Our ref: DOC22/30119

Your ref: SSD-8800

2 February 2022

Subject: EES comments on the Response to Submissions for Parramatta Leagues Club Hotel – SSD-8800 – 1 Eels Place, Parramatta

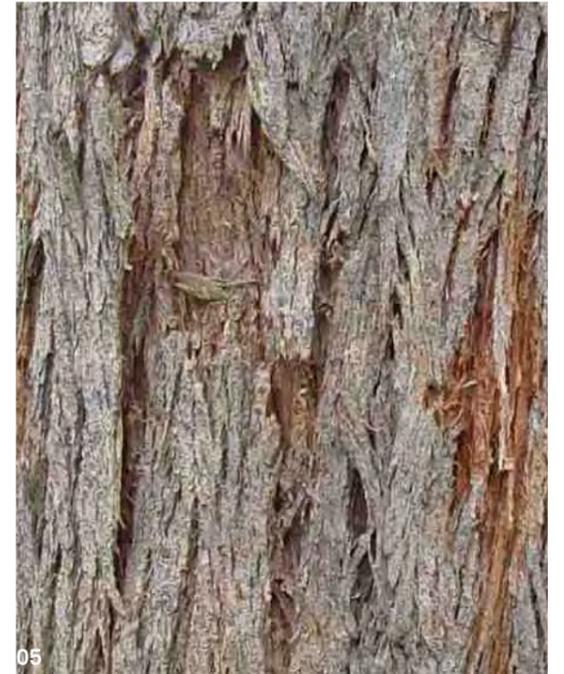
EES notes that *Eucalyptus haemastoma* is not found in any of vegetation communities that may have occurred on site. Similarly, *Corymbia maculata* and *Eucalyptus pilularis* are not commonly found in any of the vegetation communities that may have occurred on site. EES recommends that the tree species chosen for replanting are component species of the relevant vegetation community that once occurred on site.

EES recommends local native provenance plant species are used for any planting associated with the SSD instead of exotic or non-native species, particularly as the development sits on the edge of the UNESCO World Heritage Parramatta Park. EES recommends:
